Ribble Valley Borough Council
Development Control

Application no: 3/2019/0331

Address: Field Boundary Chatburn Road , Chatburn
Proposal Bridleway

SECTION 1: CHATBURN ROAD CROSSING GREEN LAKE WTS 116 METERS

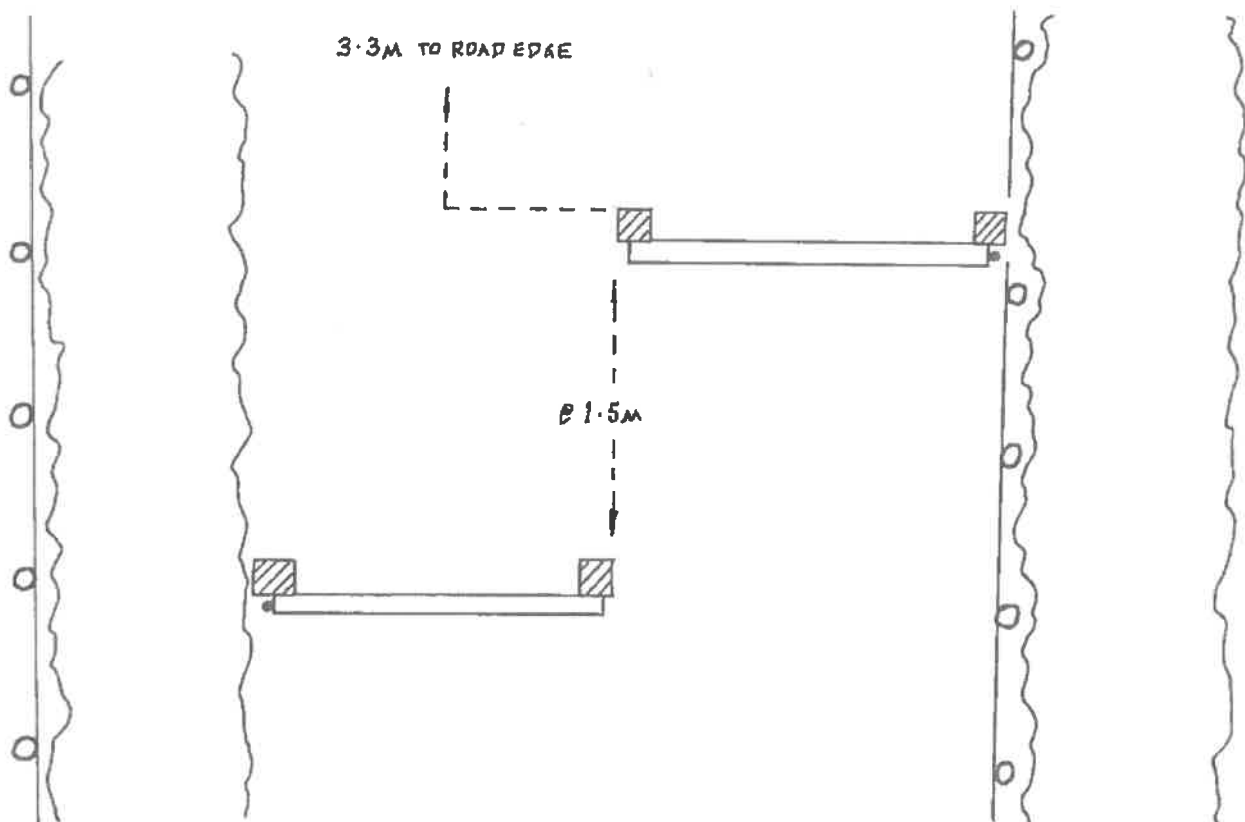
1 The visibility for users of the route as it emerges onto Green Lane to the east is poor with the adjacent boundary walls and vegetation obstructing visibility for users emerging to cross as required for the route continuation. It is accepted that the available visibility over the adjacent boundary walls may be suitable for the majority of users it doesn't not cater for the needs of wheel chair or mobility scooter users.

A similar scenario exists for users emerging onto Chatburn Road
